SECTION 4.55 (1A) APPLICATION TO AMEND SSD 10437 - WATERLOO METRO QUARTER OSD SOUTHERN PRECINCT

This letter has been prepared by Urbis on behalf of WL Developer Pty Ltd (the applicant) with regards to a Section 4.55(1A) application to modify State Significant Development (SSD) Waterloo Metro Quarter OSD Southern Precinct SSD-10437.

The modification application seeks for minor internal and external design changes to Building 3 and the landscaping. The majority of the proposed changes are internal and considered to be minor. The external changes relate to minor landscape changes, configuration of rooftop plant and inclusion of additional louvres.

Sheet title
General Arrangement Plan
Level 1 Plan

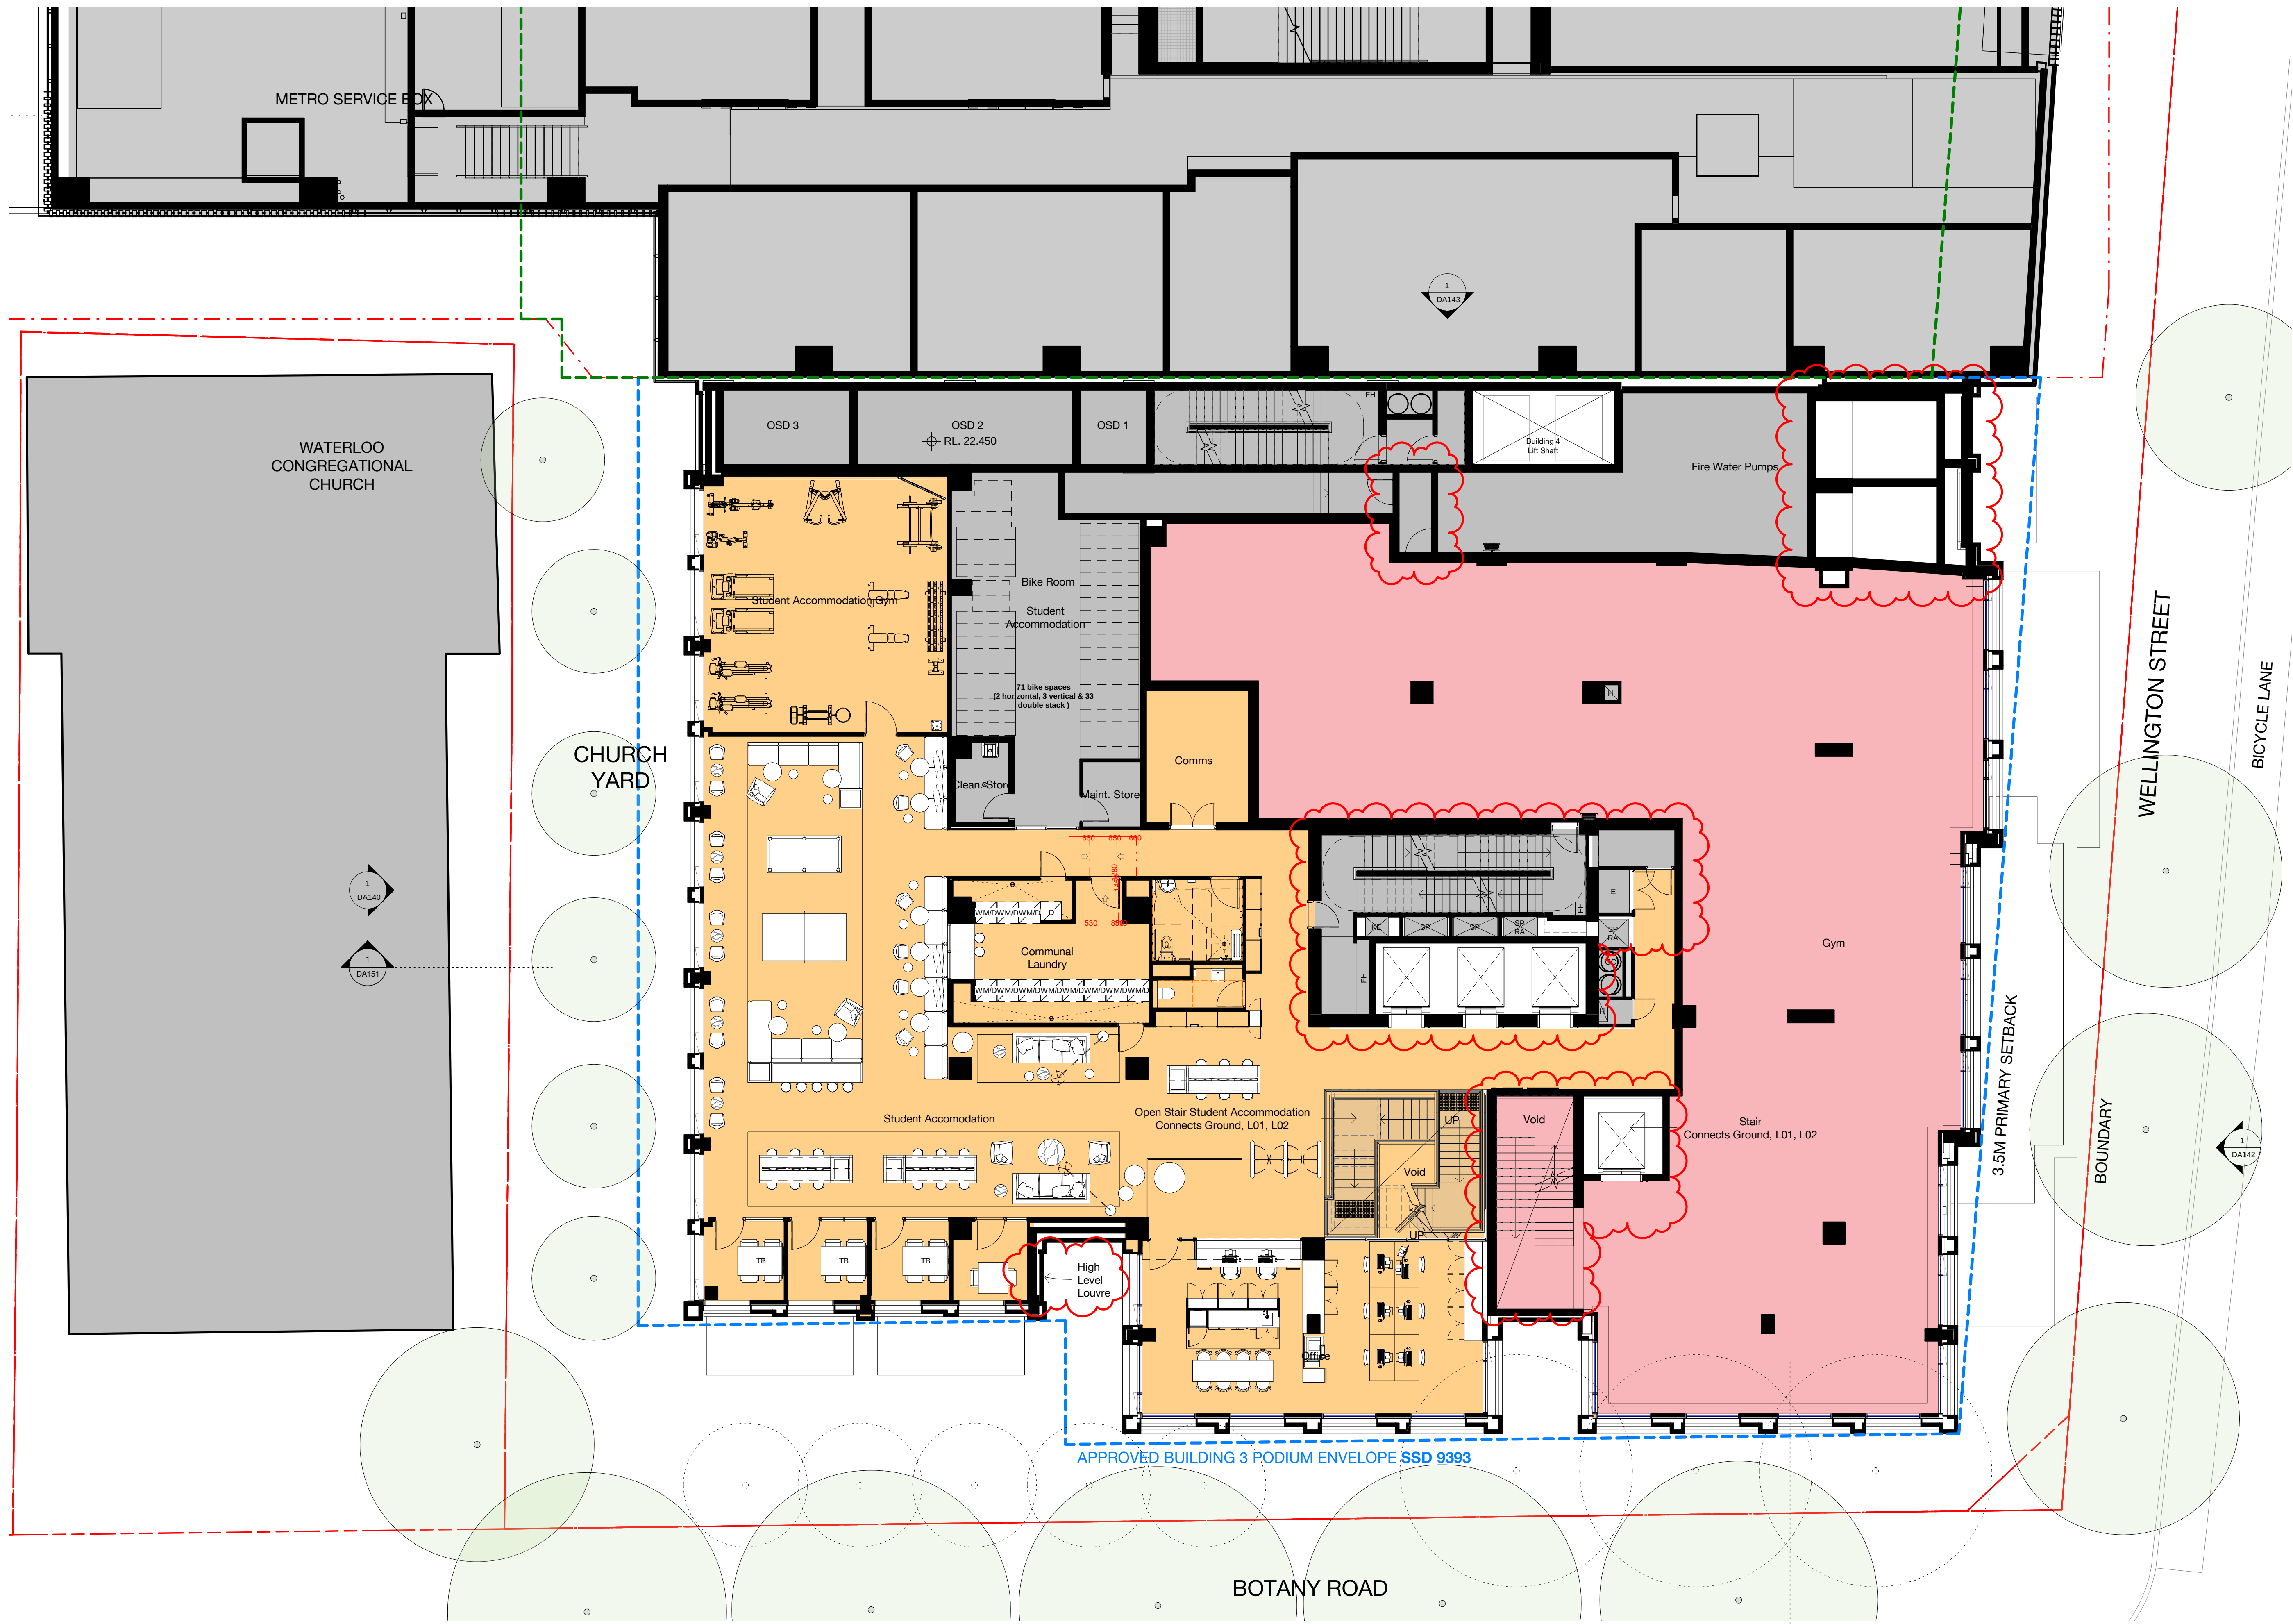
- Revise roof plant zones
 - Increase height of plant zones, not exceeding the approved Concept building envelope (RL96.9) (see below comparison of plans);
- Addition of louvre for ventilation on western elevation to Level 24 lift core
- Additional service doors to podium roof
- Addition of louvres to podium of the mezzanine level and Level 1.
- Addition of louvres to northern elevation of the ground level and Level 2

- Student accommodation – reconfiguration to the core and services areas.
- Gym – lift and stair reconfiguration
- Addition of block wall and boom gate to loading dock driveway

Sheet title
General Arrangement Plan
Roof Plan

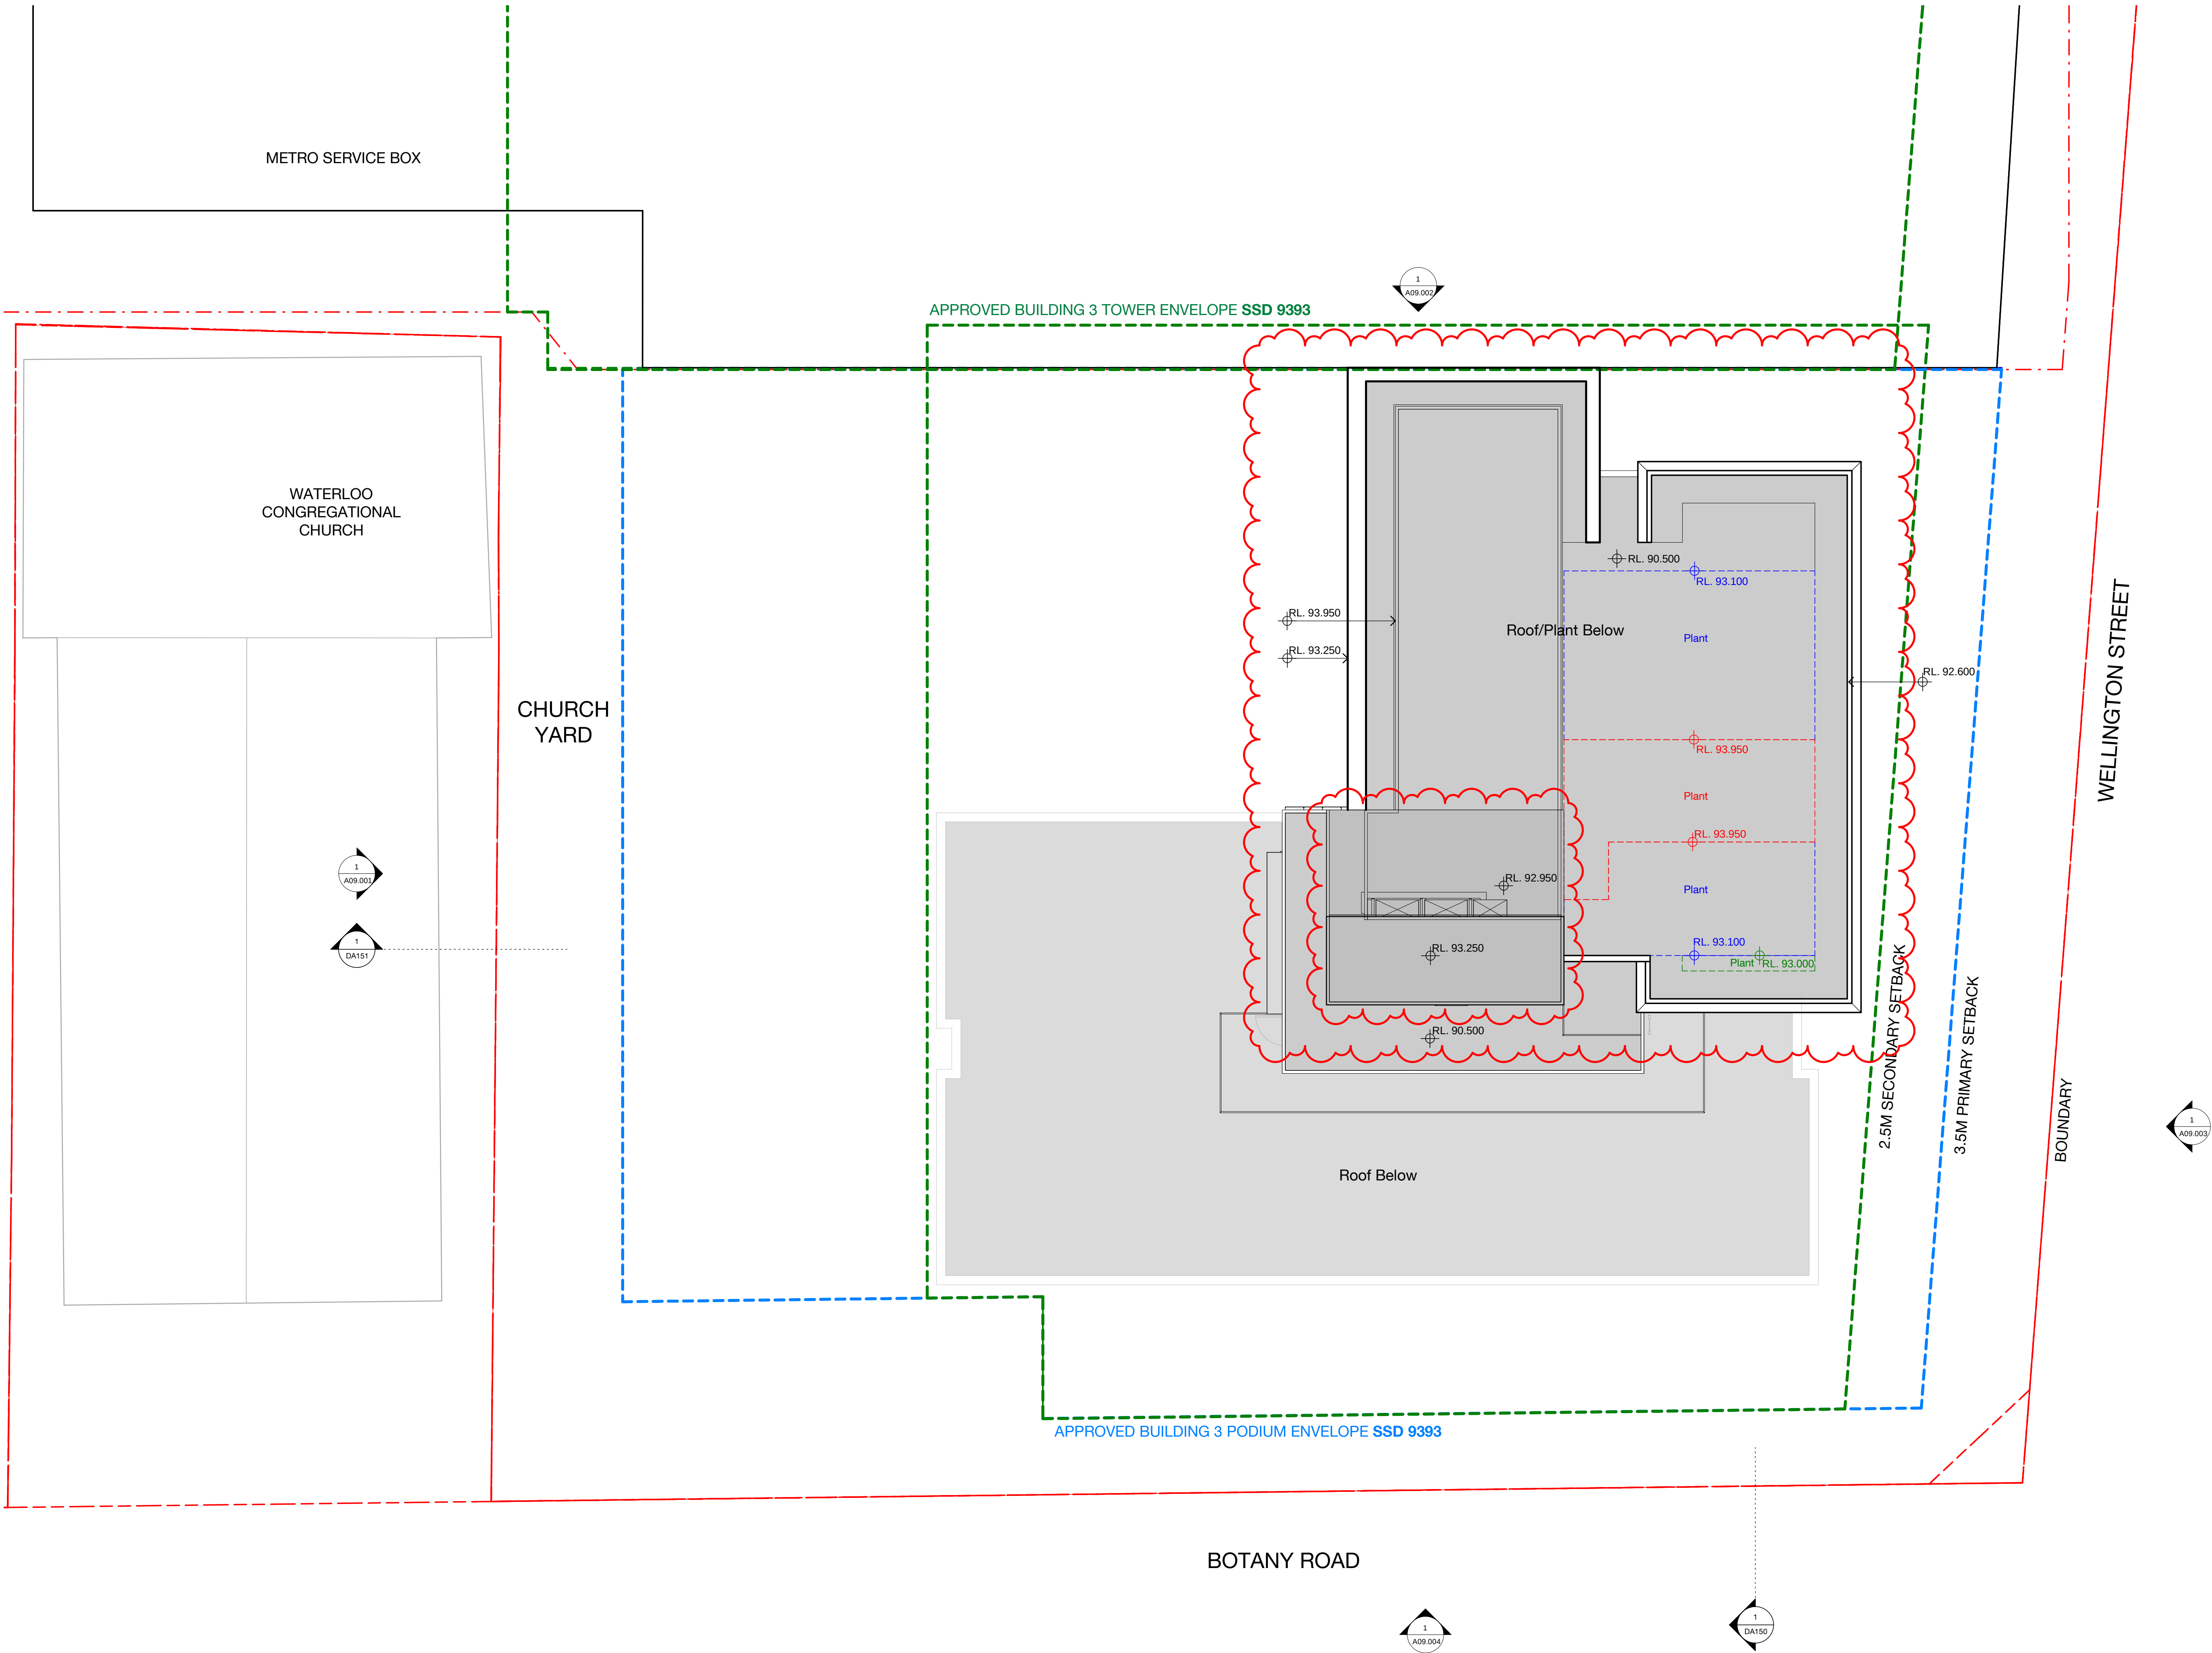
- There are no alterations to the predominant architectural design of the building.
- The revised plant zones are below the maximum height of the building, and is intended to facilitate for minor building elements. The maximum height of the building is retained and the building remains consistent with the concept DA.

- The revised plant zones are setback from the building edge and is not readily visible from the public domain.
- As the plant zones are for small roof top elements and do not exceed the maximum building height, they do not significantly impact view corridors.
